Engineers Comments Regarding Surface Water Drainage

Application Reference:	CM/11/26/DOC	Reviewer Reference:	ADC/EXT2
Planning Officer:	Kathryn Welch	Date of Review:	22/06/26
Site Name:	Rigates Climping Street Climping BN17 5RQ		
Application Description:	Approval of details reserved by condition under CM/12/25/PL relating to condition 3- Surface Water Drainage.		
Assessment Number:	1 of 2

Application Reference: CM/11/26/DOC Site Name: Rigates Climping Street Climping BN17 5RQ	Initial Issue Date: 22/06/26 Issue Date: 17/08/26 Reviewer Reference: ADC/EXT02
---	---

DWG Title	CATCHMENT PLAN	DWG No	HC-4274-001
-----------	----------------	--------	-------------

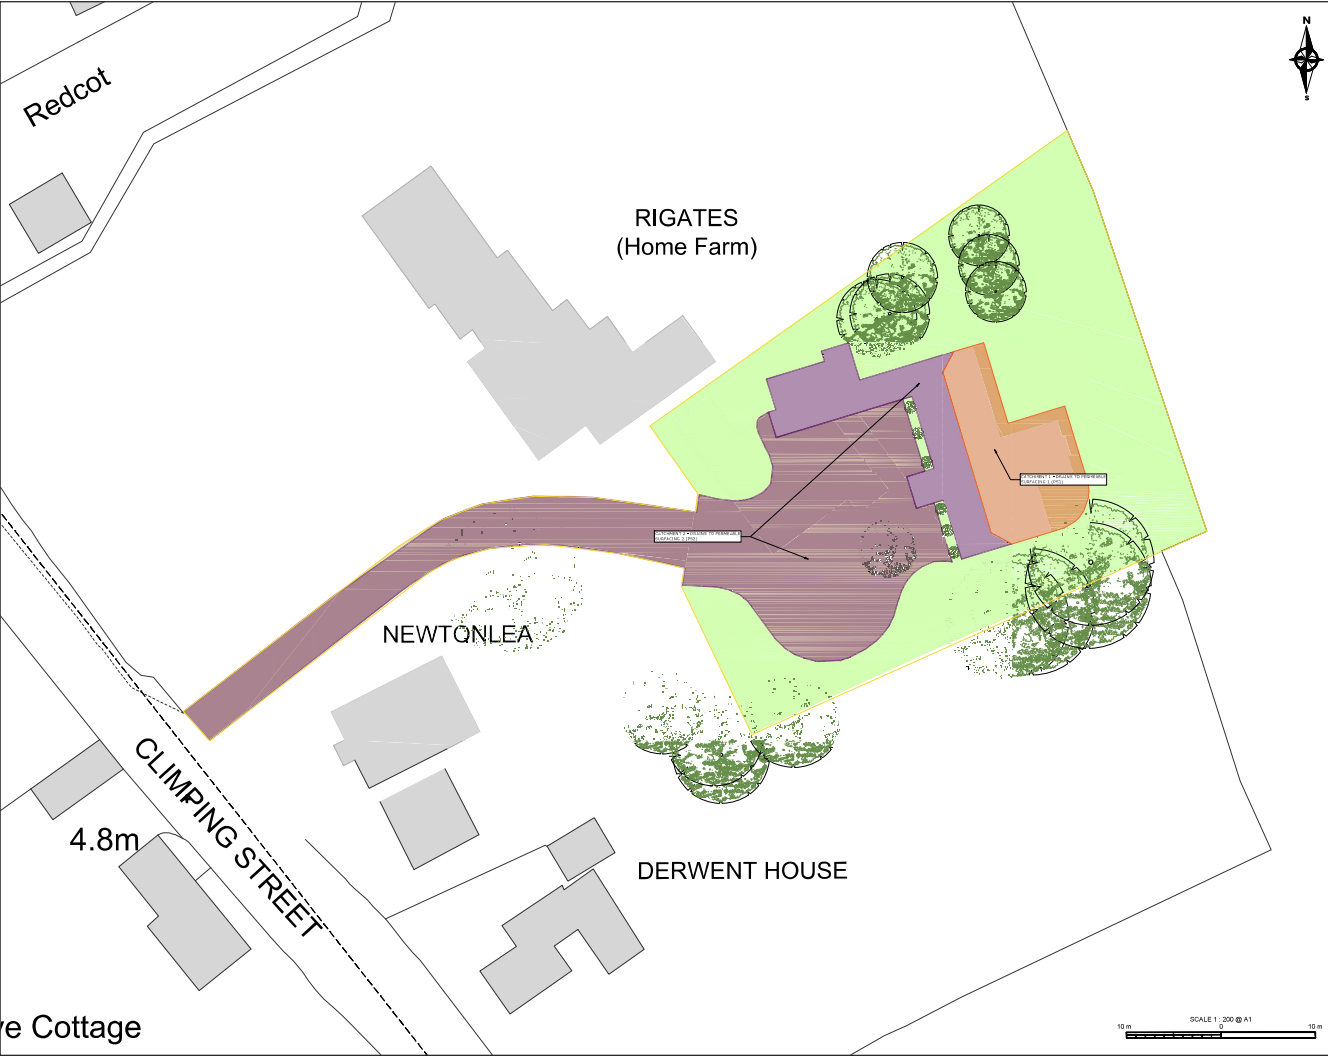
3.2. The catchment plan does not demonstrate how urban creep has been applied, although it does appear to be an allowance in the calculations. The plan should be updated.

4274.DWG.d4
SURFACE WATER DRAINAGE
LAYOUT
HC-4274-501

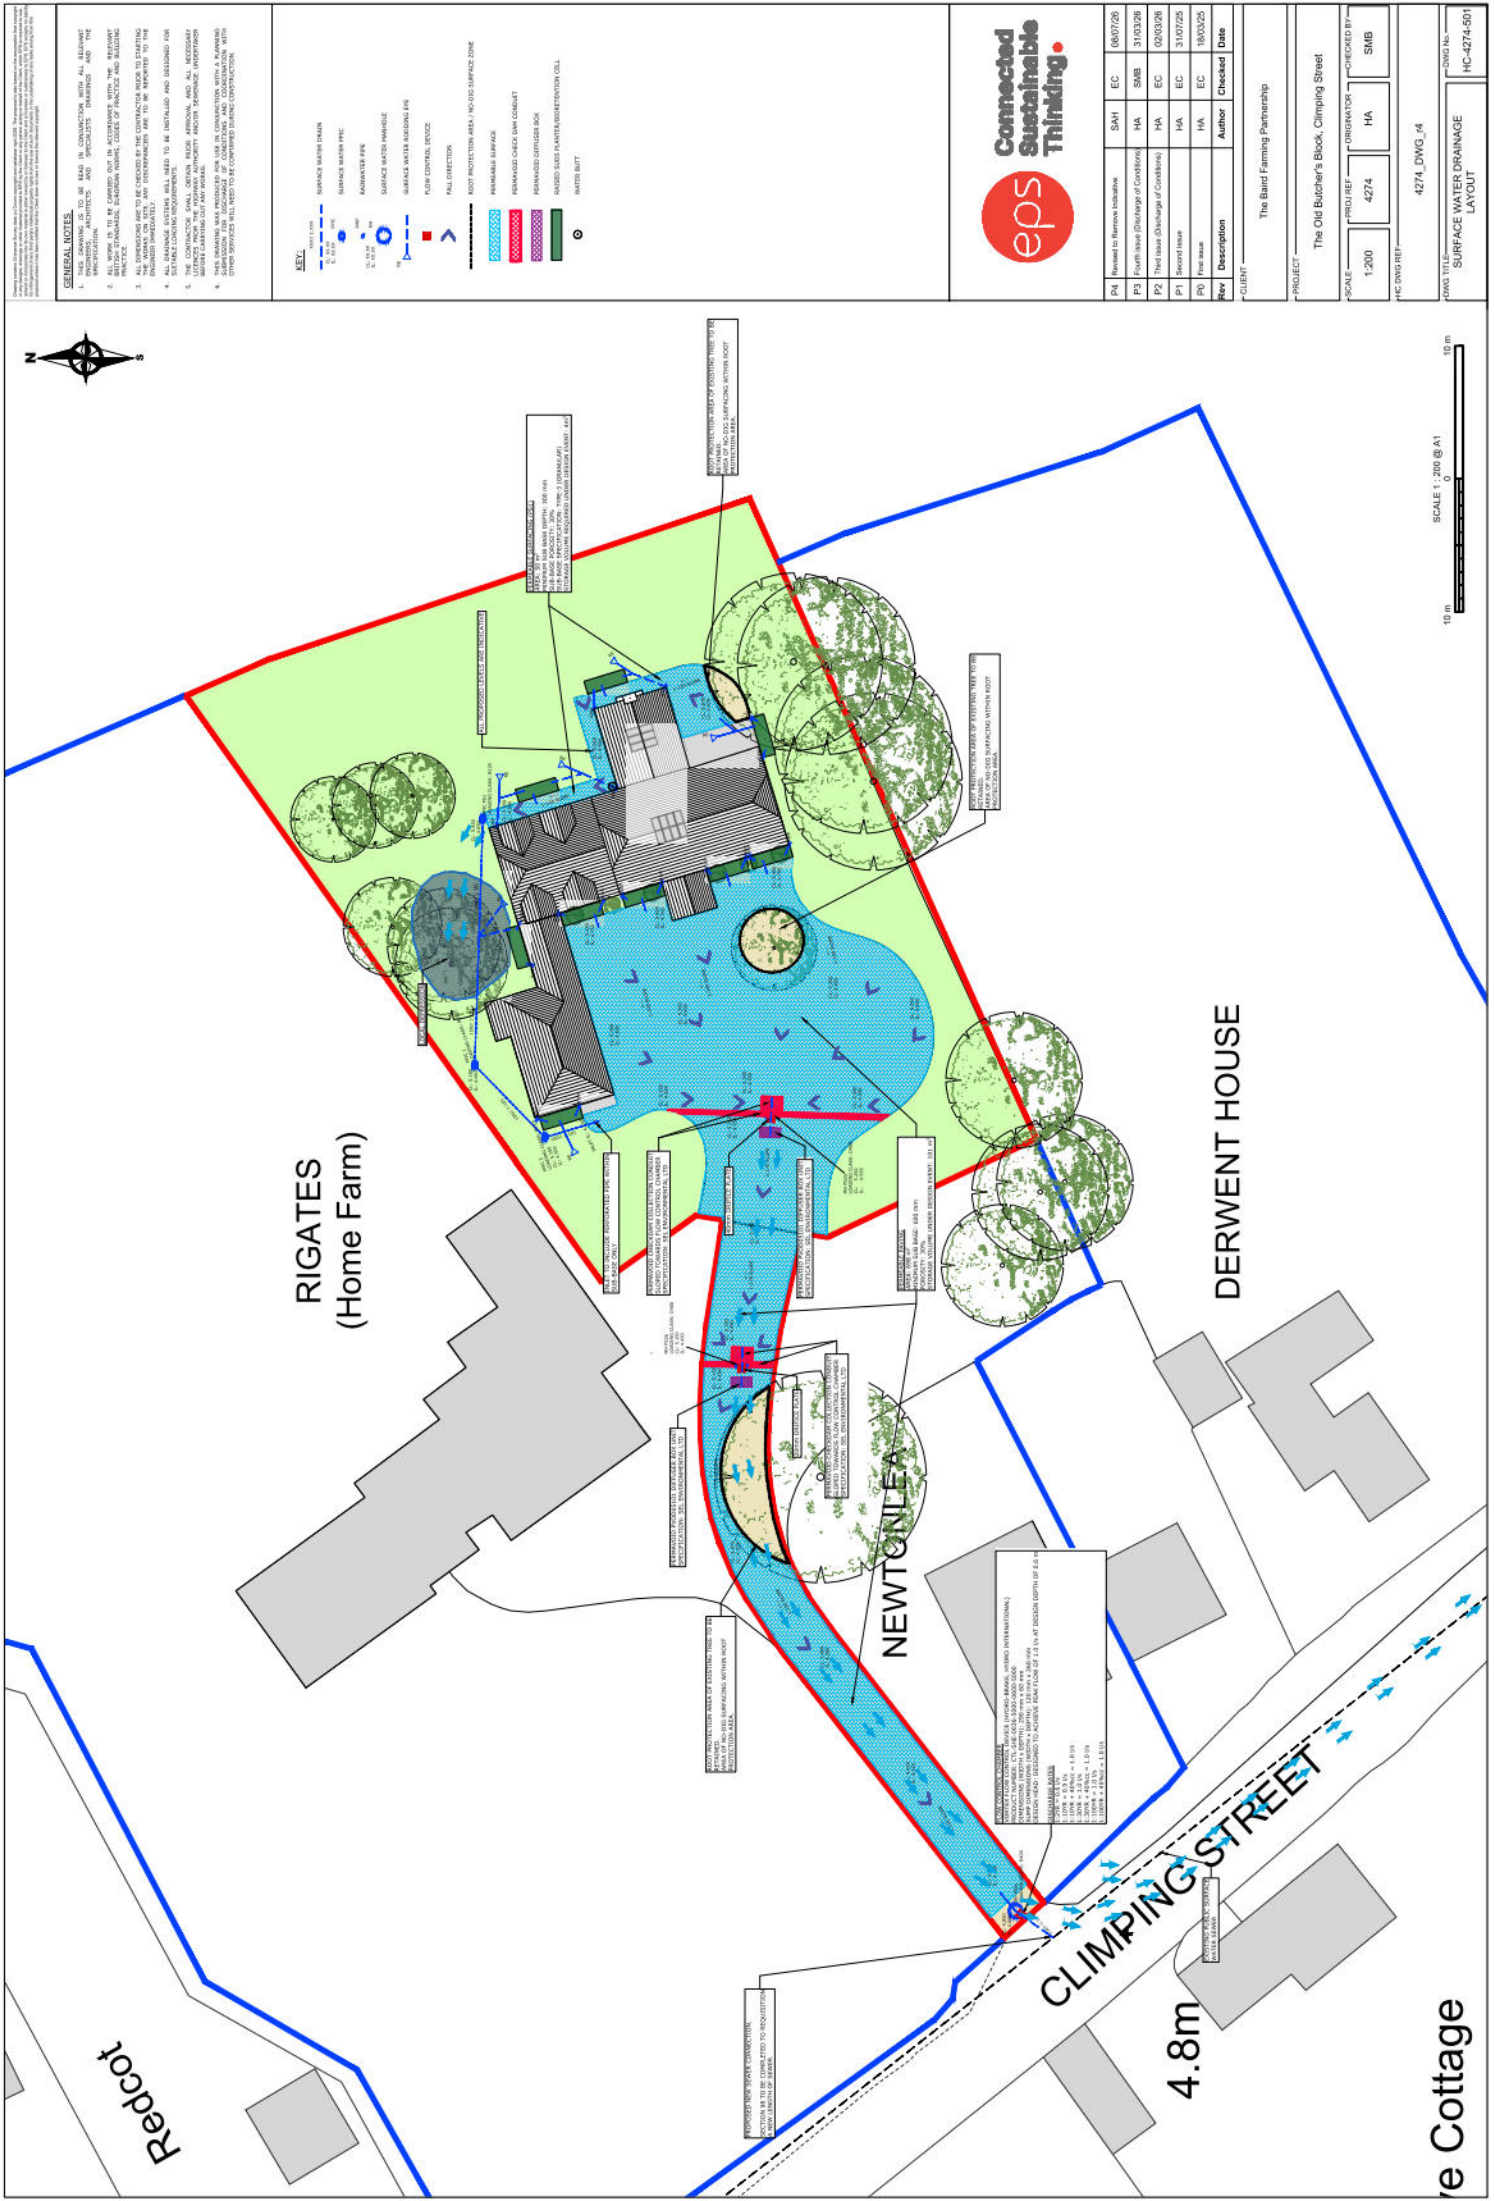
2.2. The inclusion of permeable paving when it drains its own catchment is considered to provide an adequate level of interception, however the plan appears to show the runoff from the roof connected to the permeable paving. Further interception measures may be required once the full details of the downpipe/SuDS planters, rain gardens and bioretention areas are provided.

6.	The run off from the roof appears to connect to the permeable paving which may result in the permeable paving being non-compliant as a method of interception if comment 5 cannot be evidenced. (Standard 2)		Comment still stands.		
7	Details of the existing and proposed external levels have not been submitted. This is required to verify the calculations (Standard 3)		Provide a clear plan showing existing and proposed levels. Note this is required to assess if there is any run off from other areas entering the proposed drainage system. Eg

DWG TITLE	DWG No.
SURFACE WATER DRAINAGE DETAILS	HC-4274-502

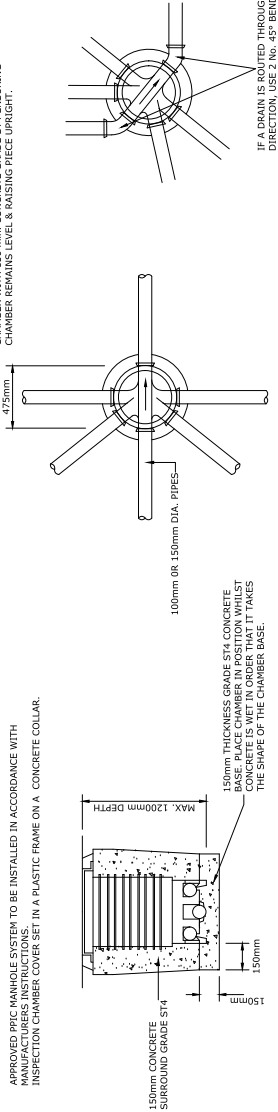
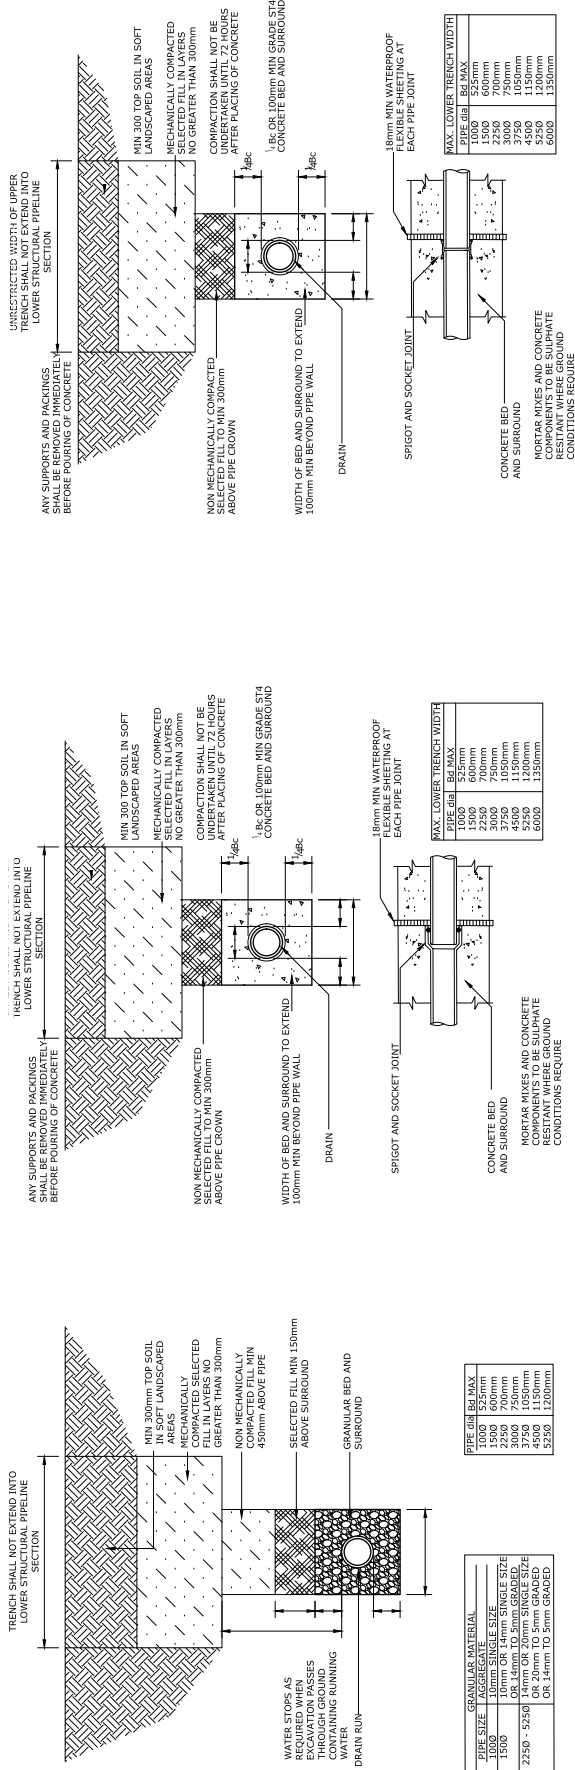
17	Demonstrate that soil particles/fines from the SuDS planters will not migrate to the permeable paving sub base.		A response to this comment does not appear to have been provided.		
19			With regard to point 3.7 in the report, the current flood maps for planning show that the site is at risk of flooding from rivers or the sea in the future. Provide an assessment of the effect that this will have on the development and the surface water drainage system together with mitigation to limit the effect, If required.		
20			Details of the proposed check dams have now been provided but not state the size of the orifice that is required. The plan shows varying sizes, this should be reflected on the detail. Similarly, the full specification/product codes should be provided for all components, eg. WASP membrane is available in various gauges.		
21			Ensure that all drawings are coordinated. Eg. the

sub base specified on drawing 502 differs to that specified on drawing 504		
--	--	--	--	--	--
